**Application Number:** 2013-045      **Application Date:** 02/13/2013  
**CBL:** 085 S003001      **Application Type:** Level I Site Alteration  
**Project Name:** PWD Sewage Pumping Station  
**Address:** 0 GREAT POND RD  
**Project Description:** Construction of a sewage pumping station to enable extension of the municipal sewer system.  
**Zoning:** IR2

**To:** FILE  
**From:** Shukria Wiar  
**Subject:** Application ID: 2013-045  
**Date:** 4/3/2013

Project Name: PWD Pump Station on Peaks Island  
Address: Great Pond Road  
Applicant: Portland Water District

GENERATOR BUILDING MECHANICAL PLAN

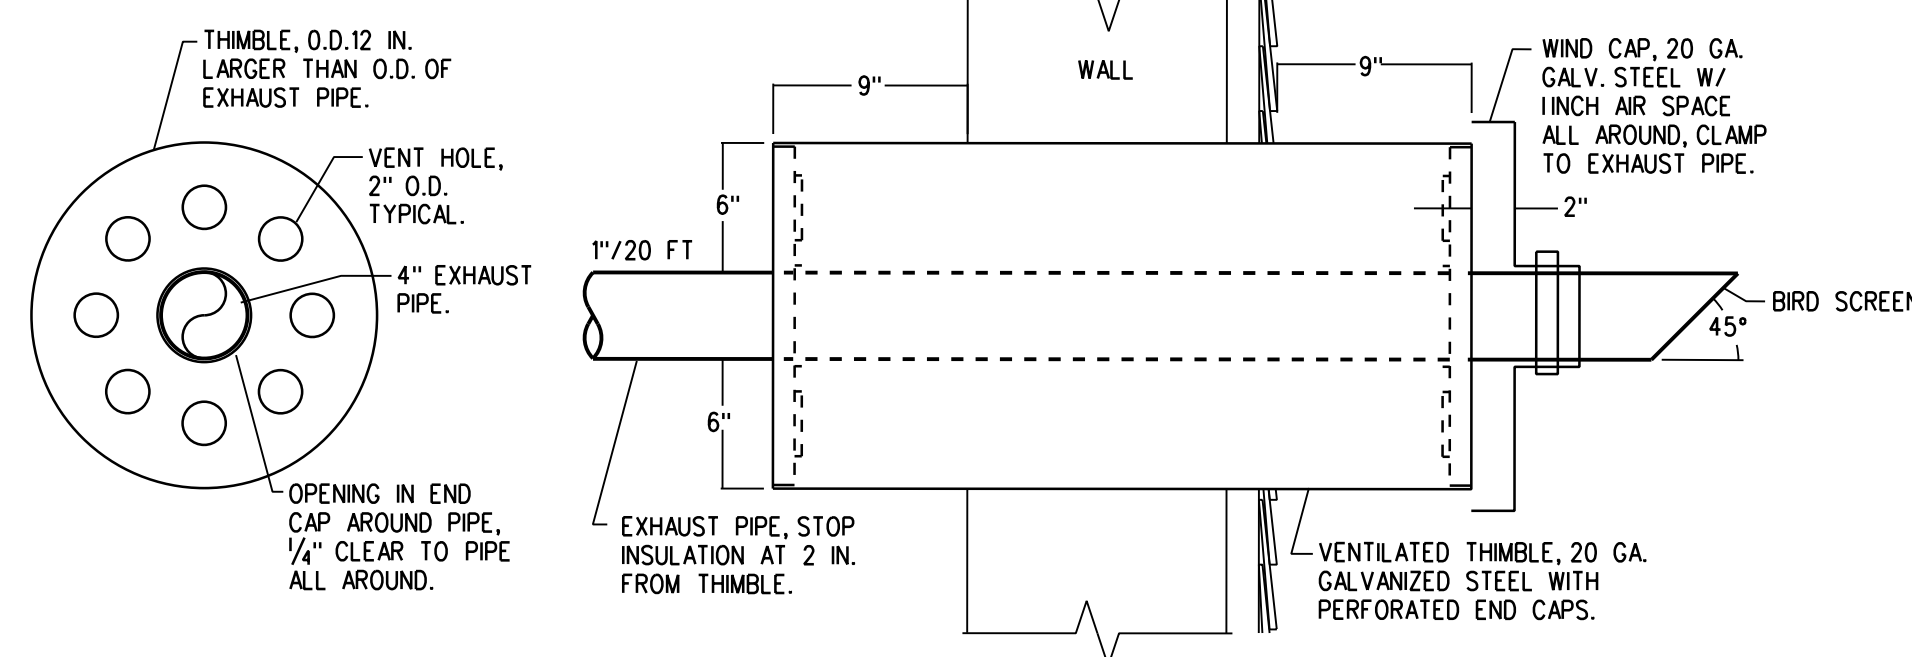
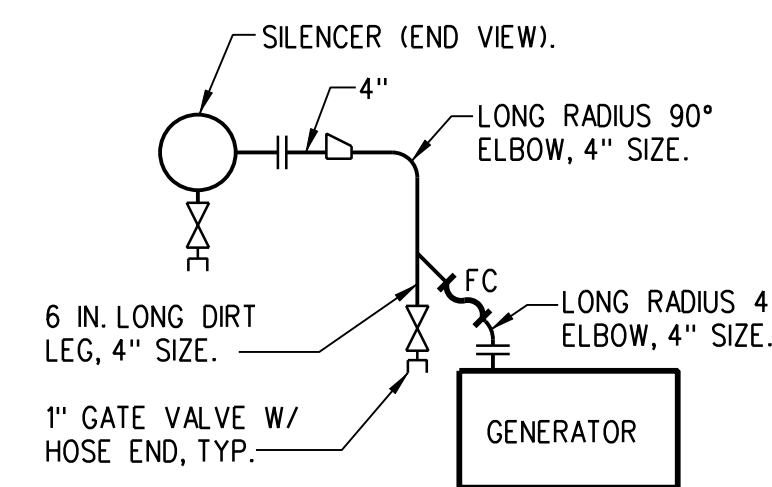
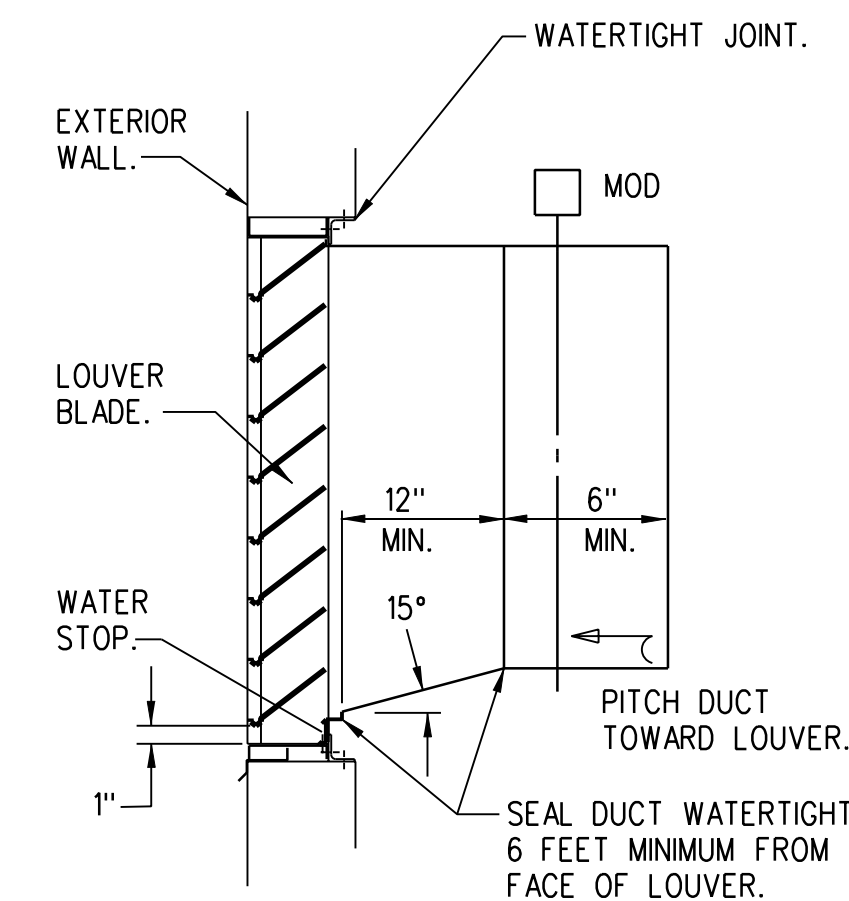
*Please submit the detail on the emitting dBAs for the units being installed (generator) and meet the maximum noise regulations.*

Sound data from the generator manufacturer is provided herein. It should be noted that the generator will be located within a building and an exhaust silencer will be installed. As a result, the sound levels are expected to be lower than those reported on the provided data sheet.

PUMP STATION SITE PLAN
SCALE: 1" = 10'

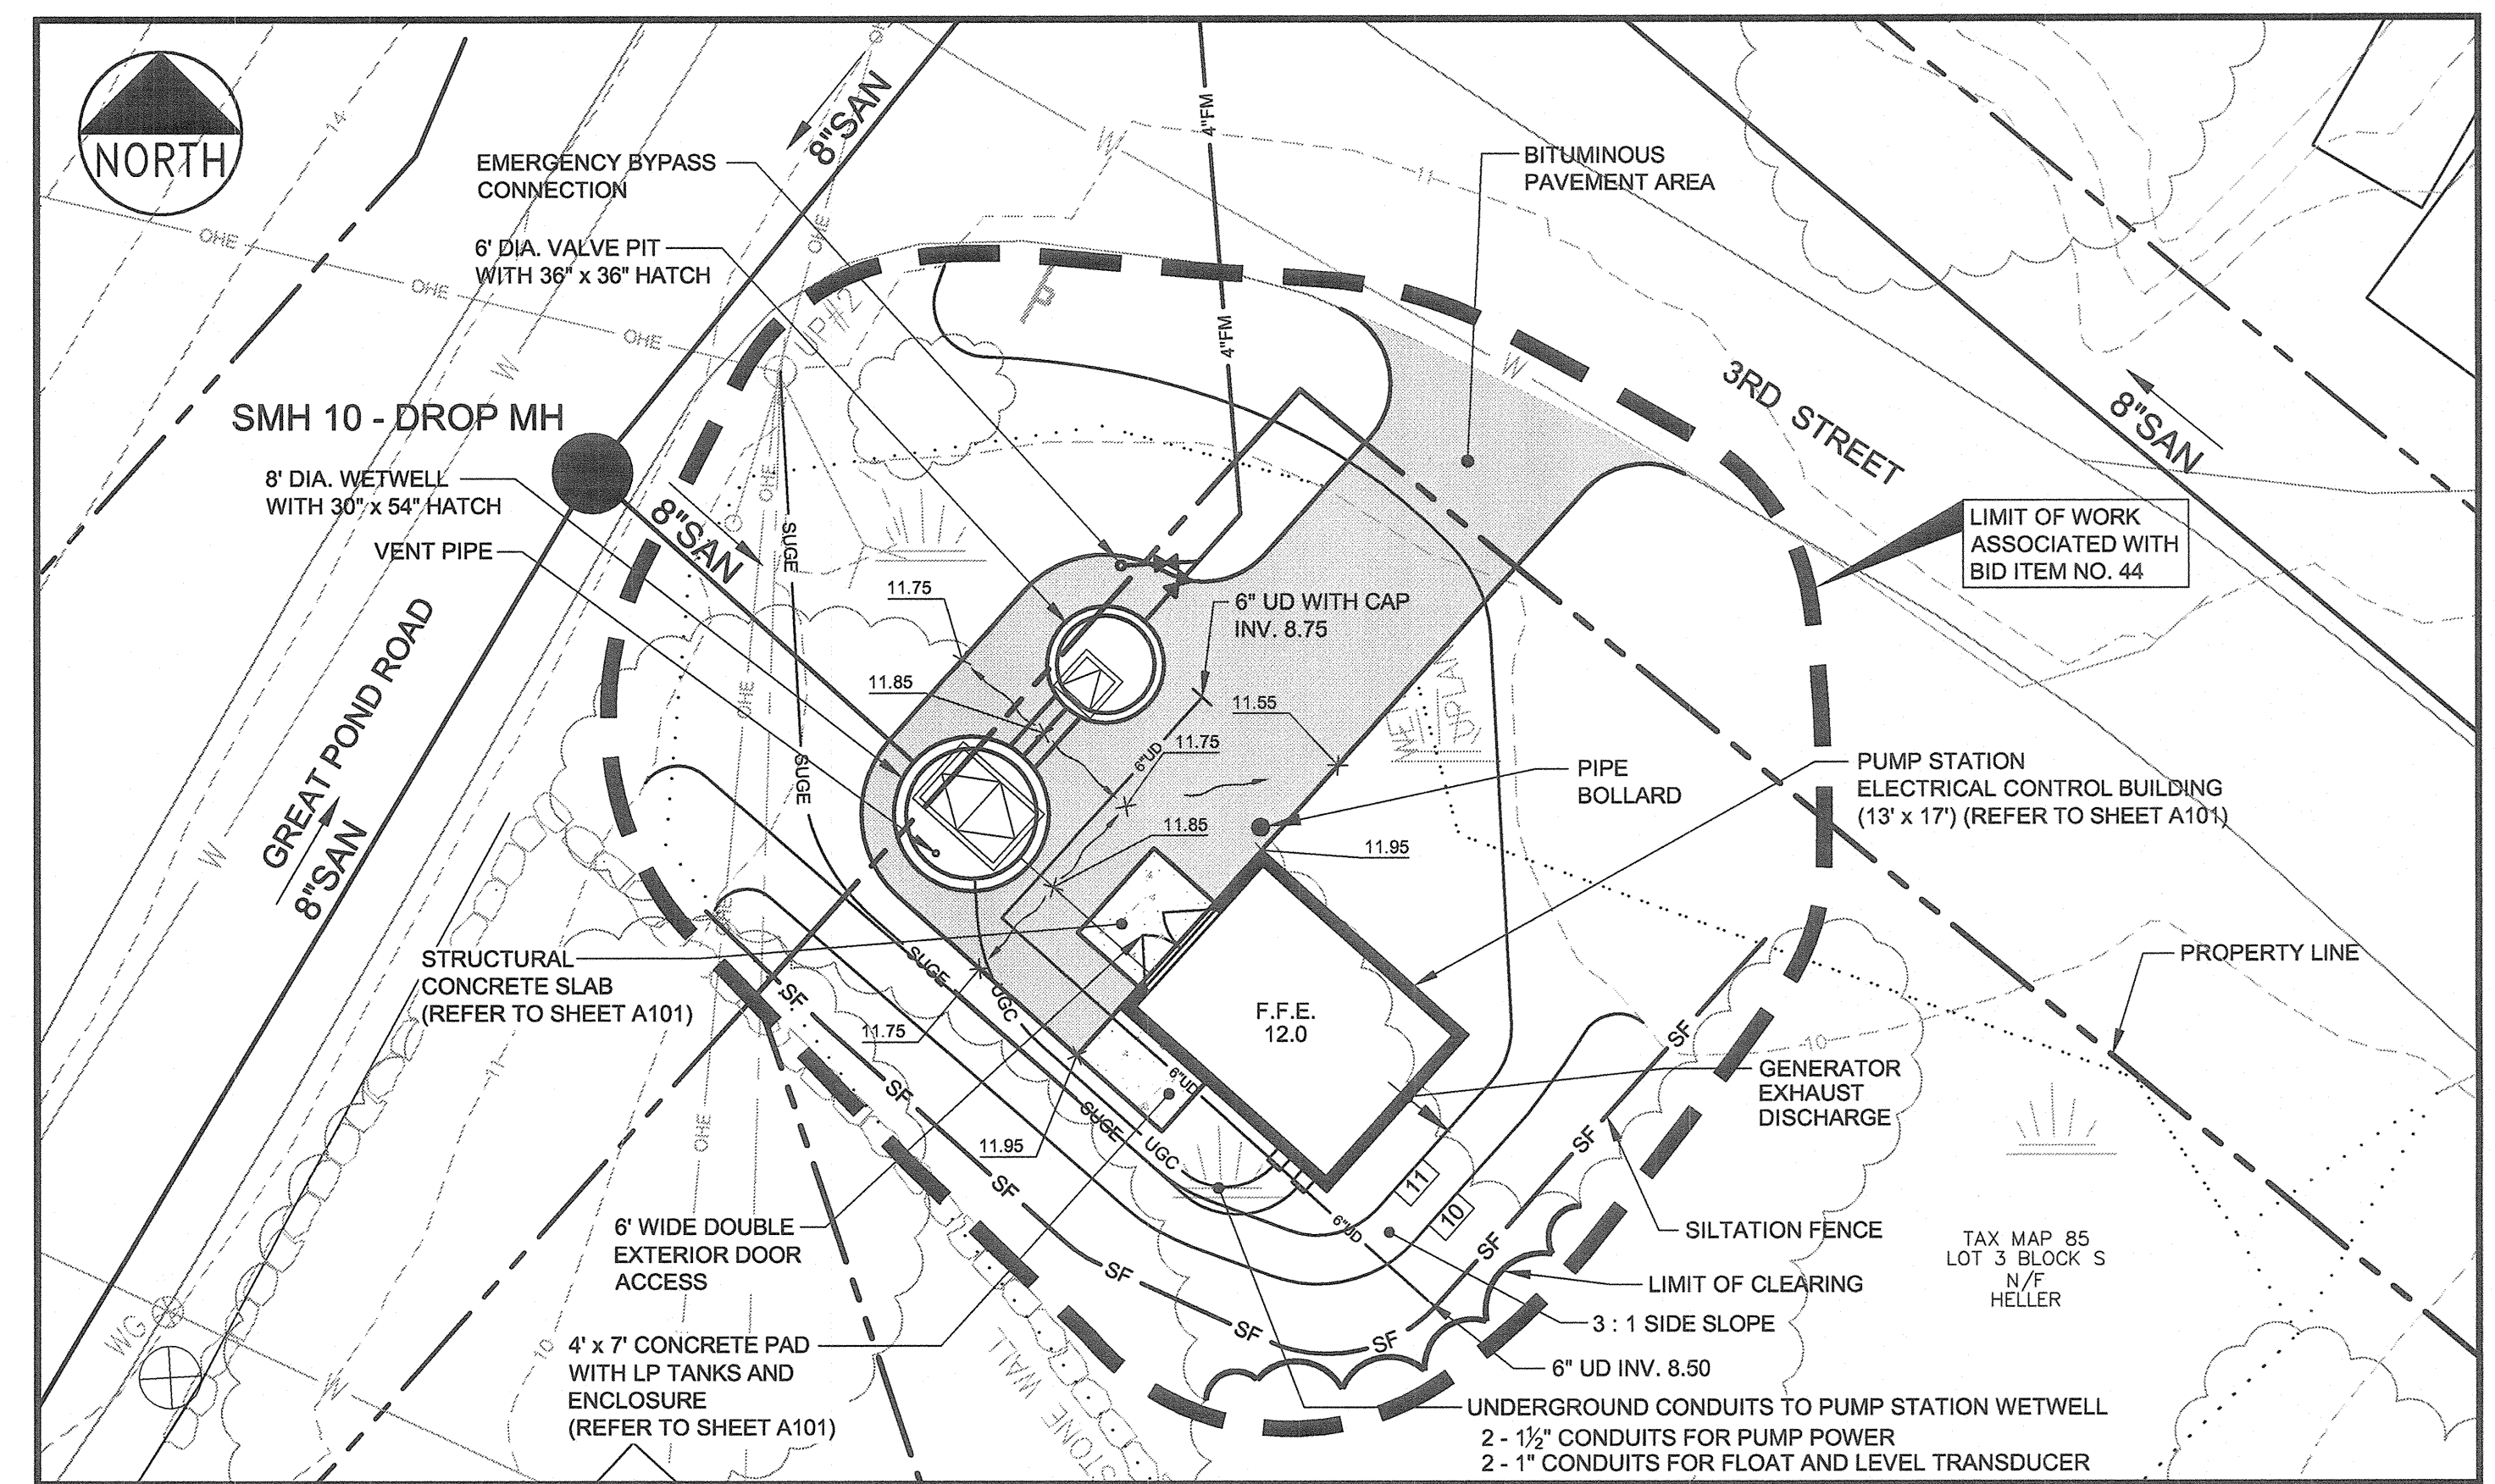
1. A financial capacity letter shall be submitted for review and approval prior to the issuance of a building permit.
2. The applicant shall add a note to the final S-1 or L-101 plan stating the stormwater runoff from the site will be treated by means of landscaped buffer/ wooded areas south of the new building and driveway.
